## 71 Caddie Lane plans review

Pursuant to your email of October 5 and our phone conversation of October 6 and to reflect additional information that has come to light, we have made changes to the drawings as outlined below. We are including drawings that have not been revised so that you can have a complete set, hopefully not jumbled in the City system as was the case when we spoke.

**4 PARTITION TYPE P4**

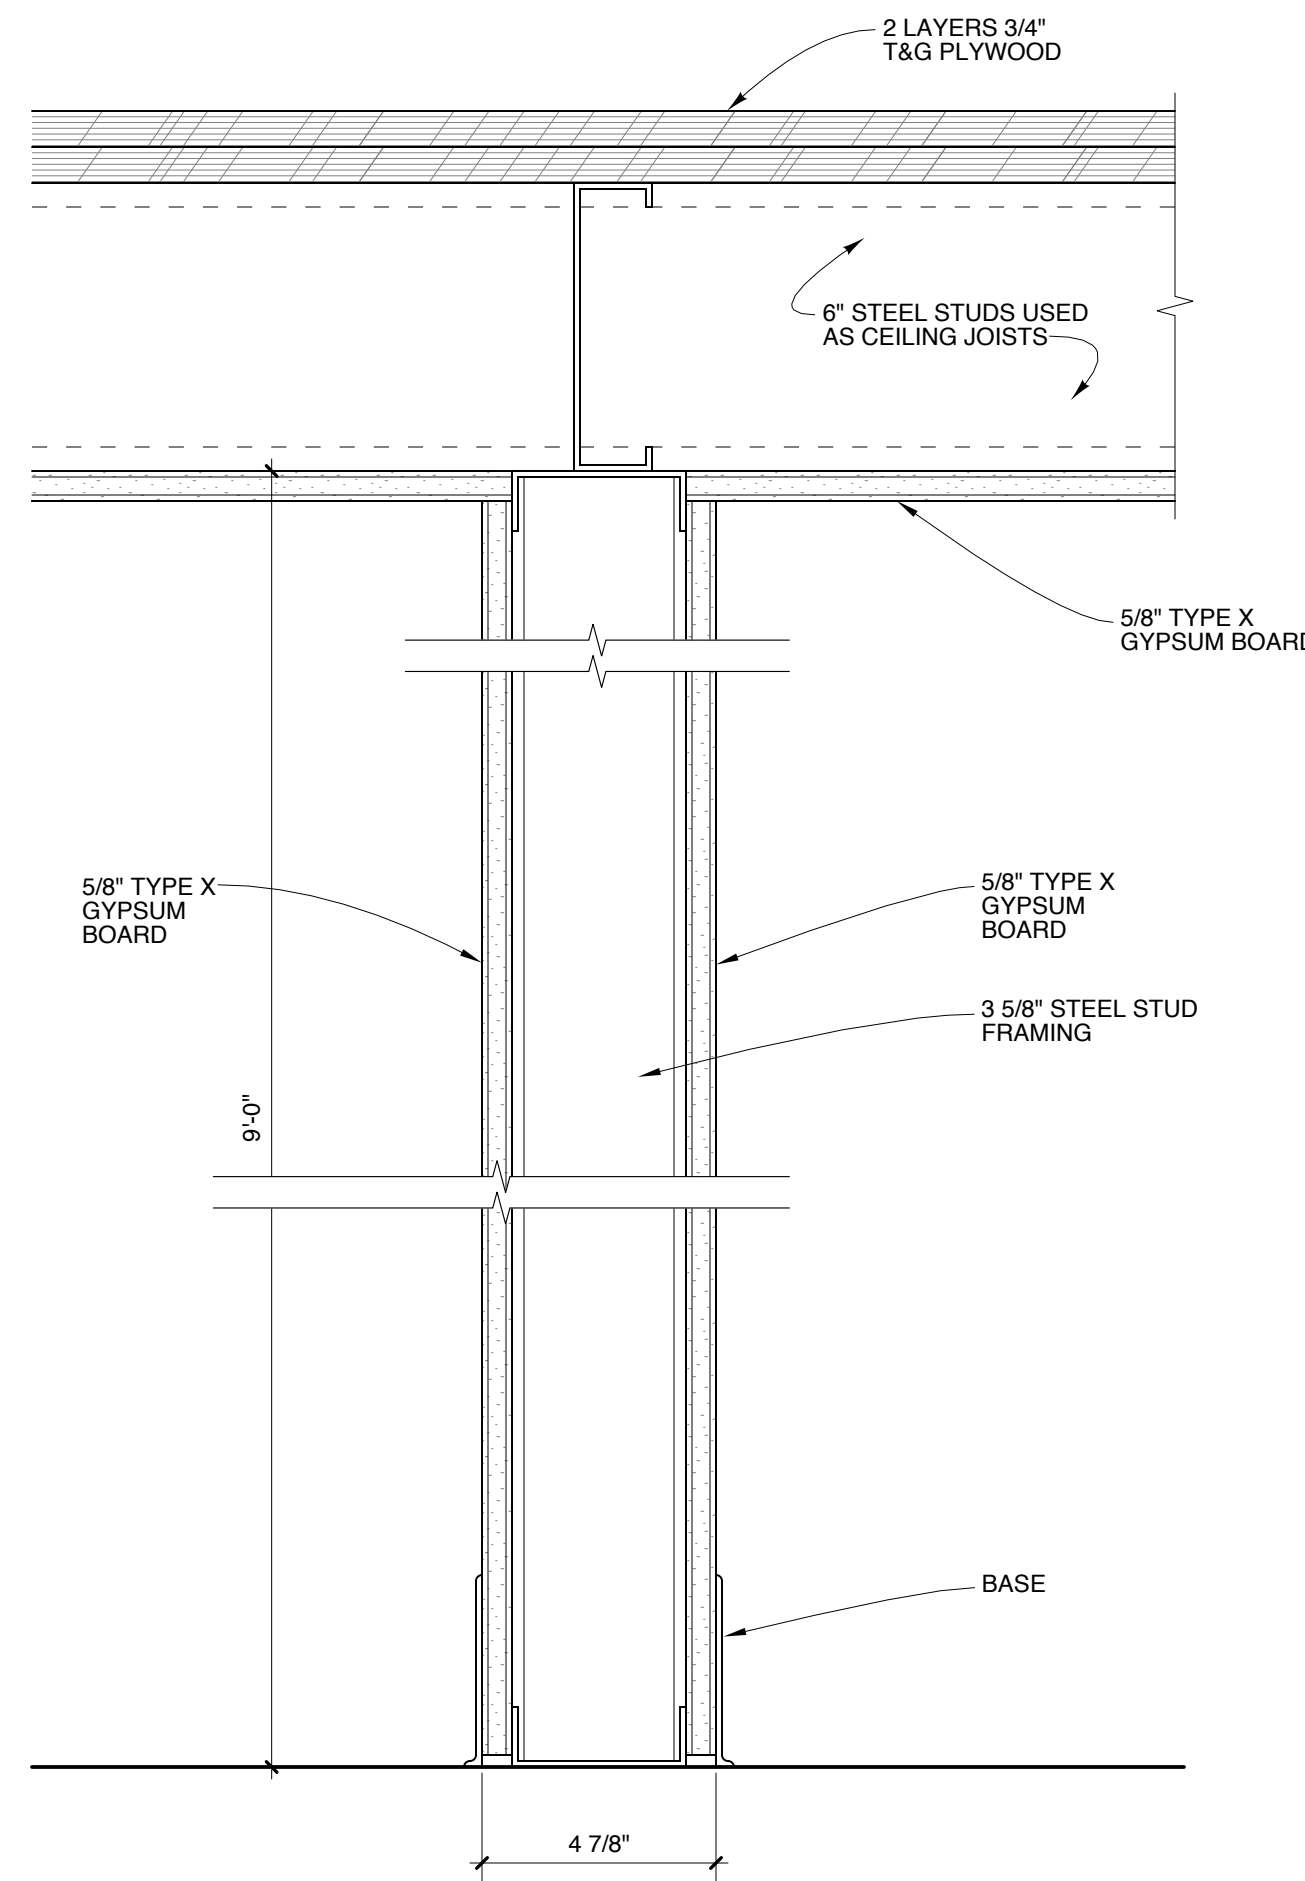
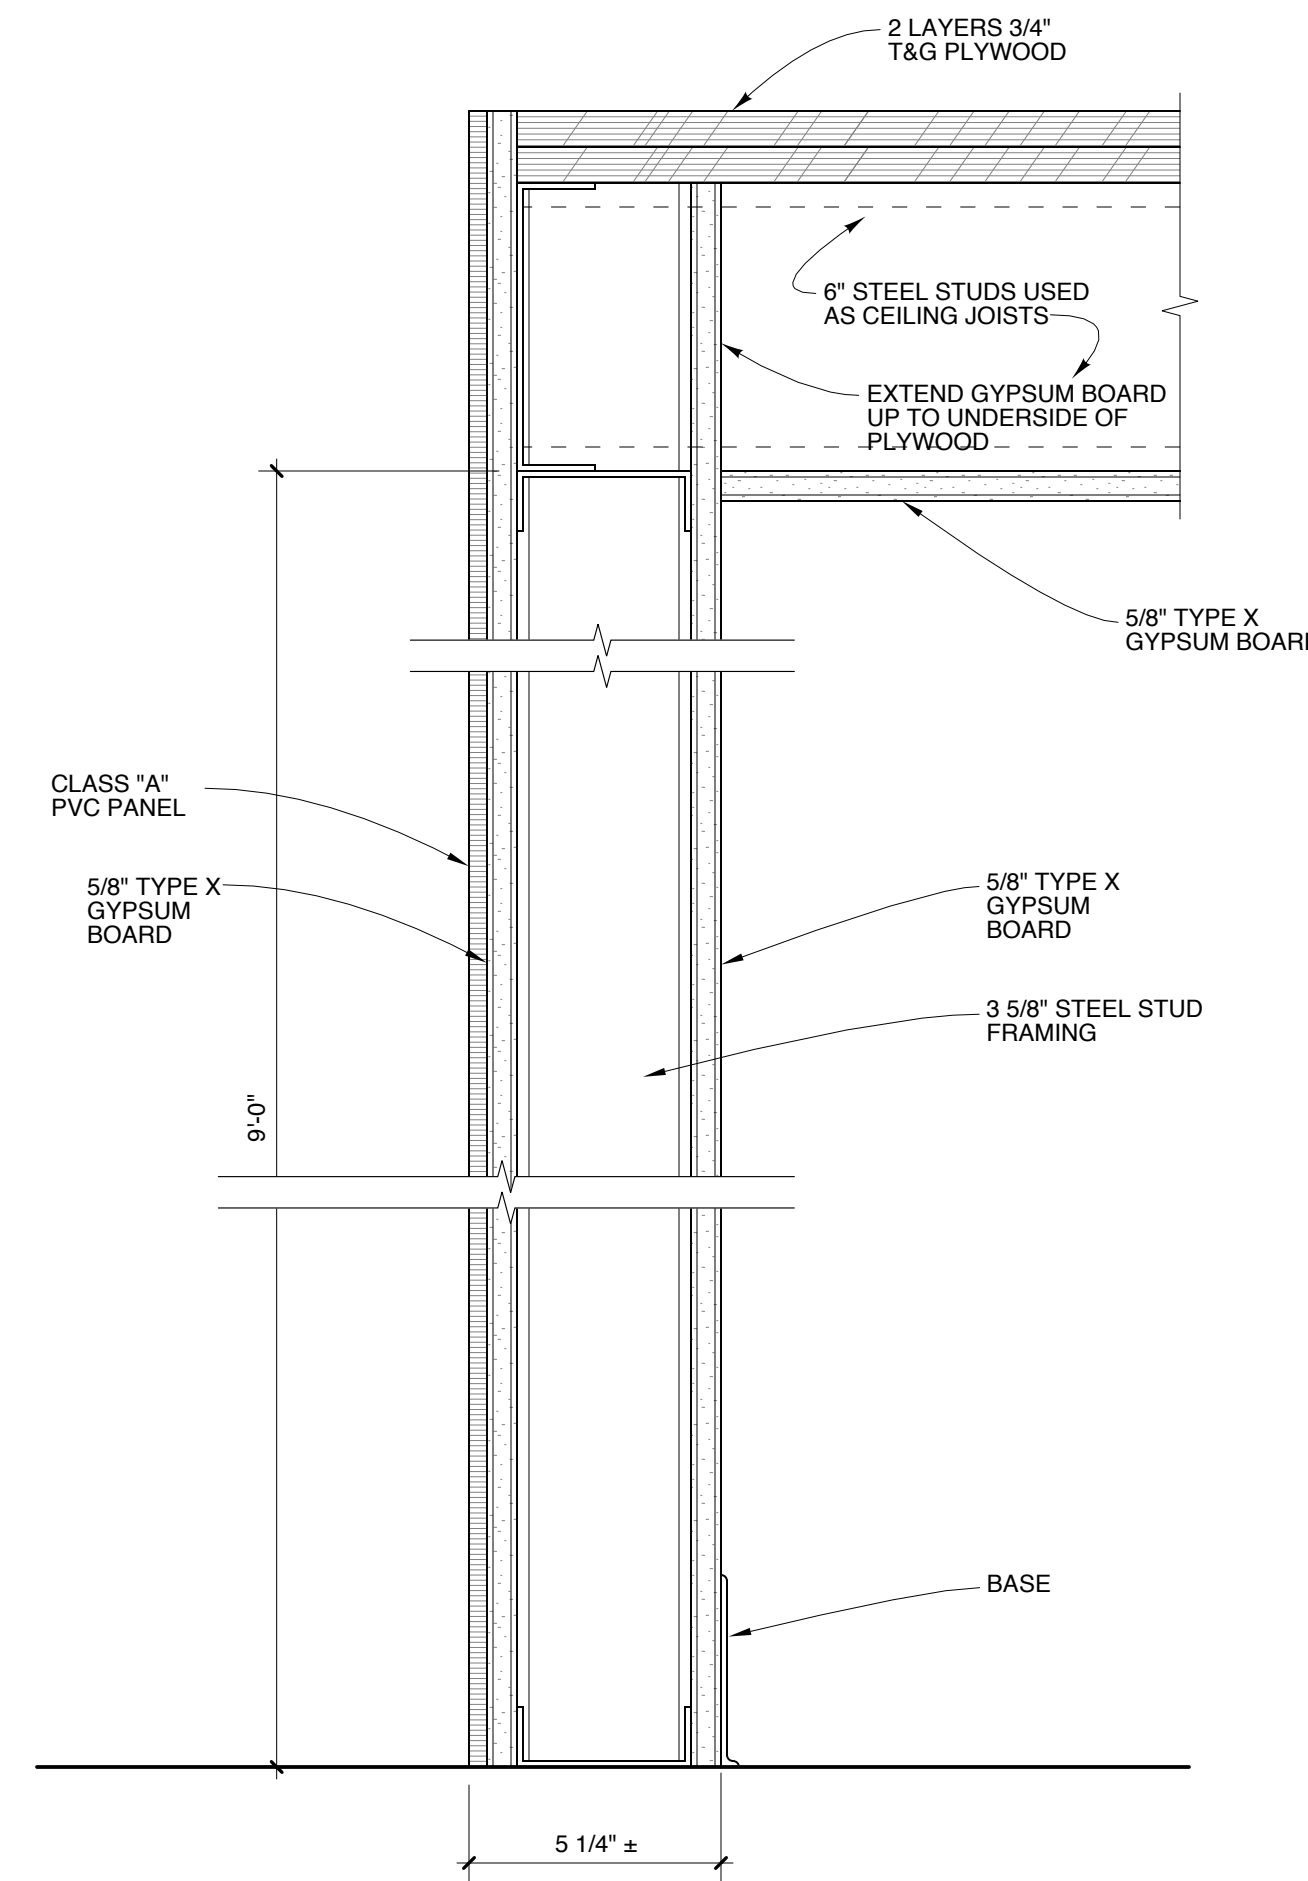
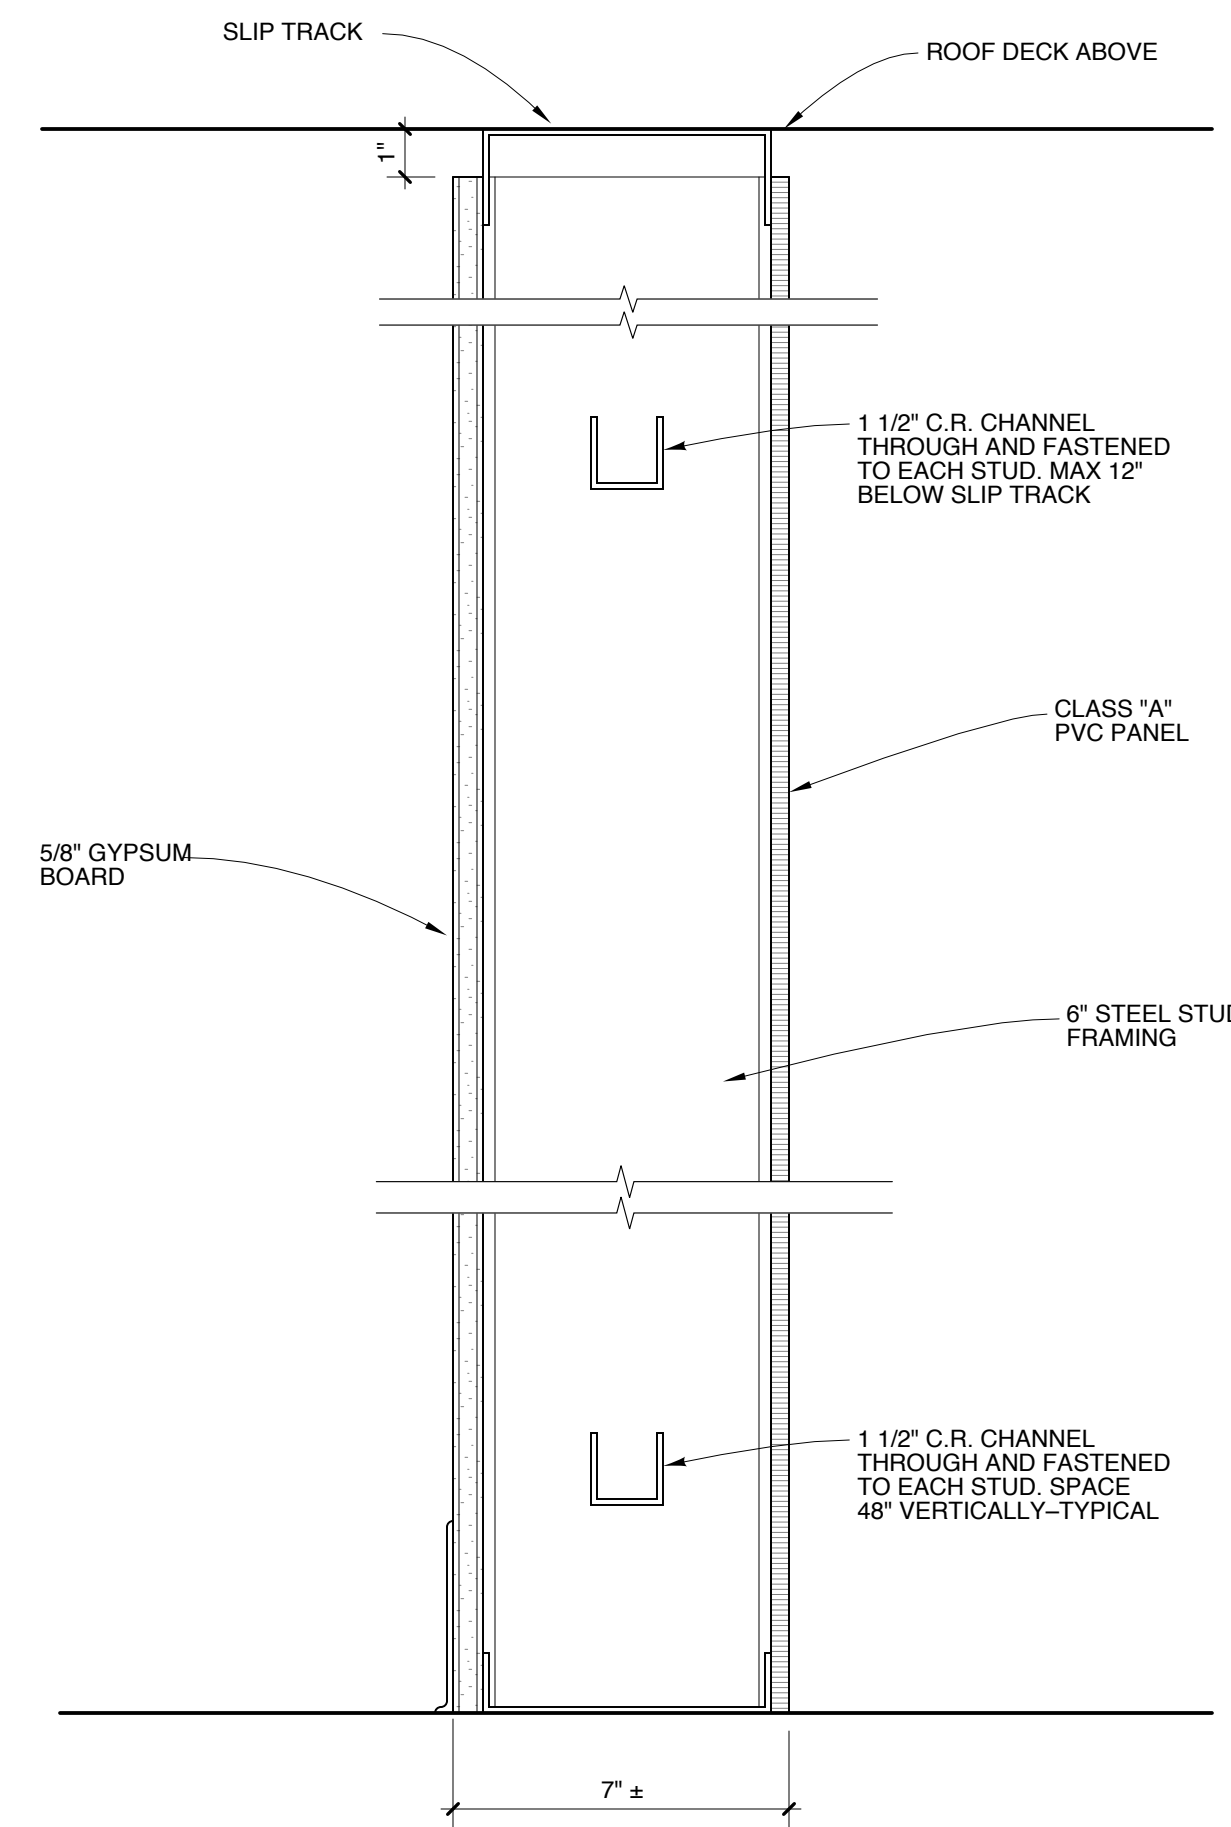
- Your question 1 on the second floor plan was already partially addressed in the shell permit. Details have been added to the partition types that show the exterior wall finish detail: 1 1/2" deep hat channels run vertically at 24 inch horizontal spacing with Class "A" PVC panels running horizontally floor to ceiling. Class "A" PVC panels have been added to other partition details.

- Partition types have been revised to show Class "A" PVC panels in various locations.
- Fire rated bearing walls are now detailed to show gypsum board extending to the underside of the floor deck above on both sides of the wall.
- Drawing is dated 10/18/17.

7 PLAN DETAIL: MEZZANINE
 SCALE: 3/4" = 1'-0" (NOT TO SCALE REF: 1 & 2/A1 REF: SSK-01)

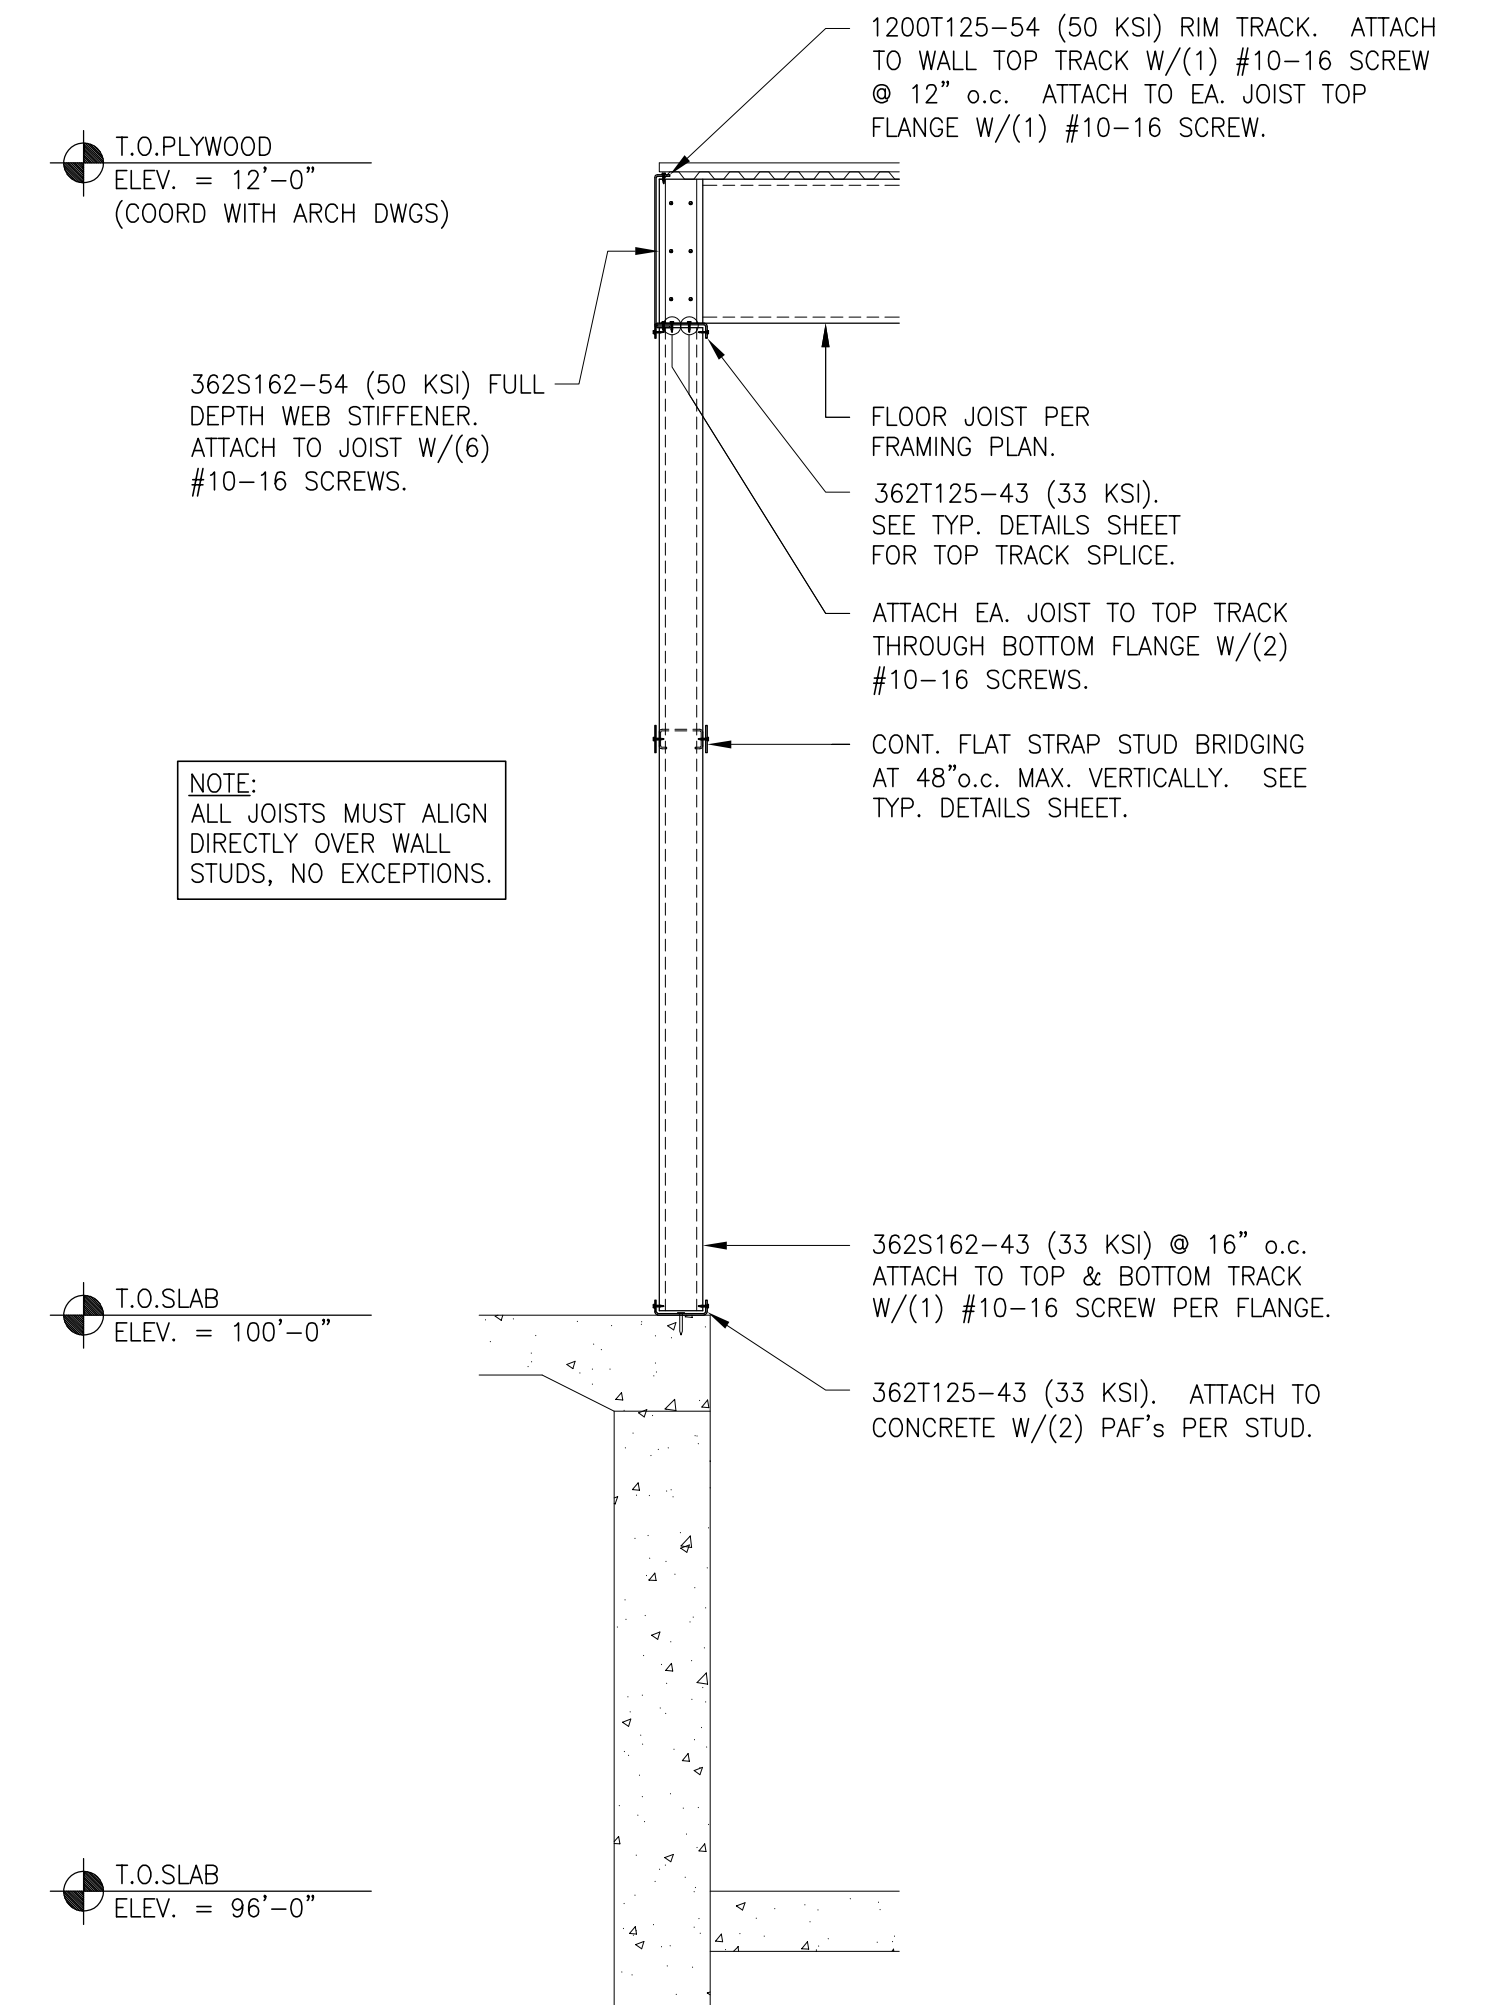
- Detail 7 added showing tie-in of floor framing to building steel frame.
- Drawing is dated 10/18/17.
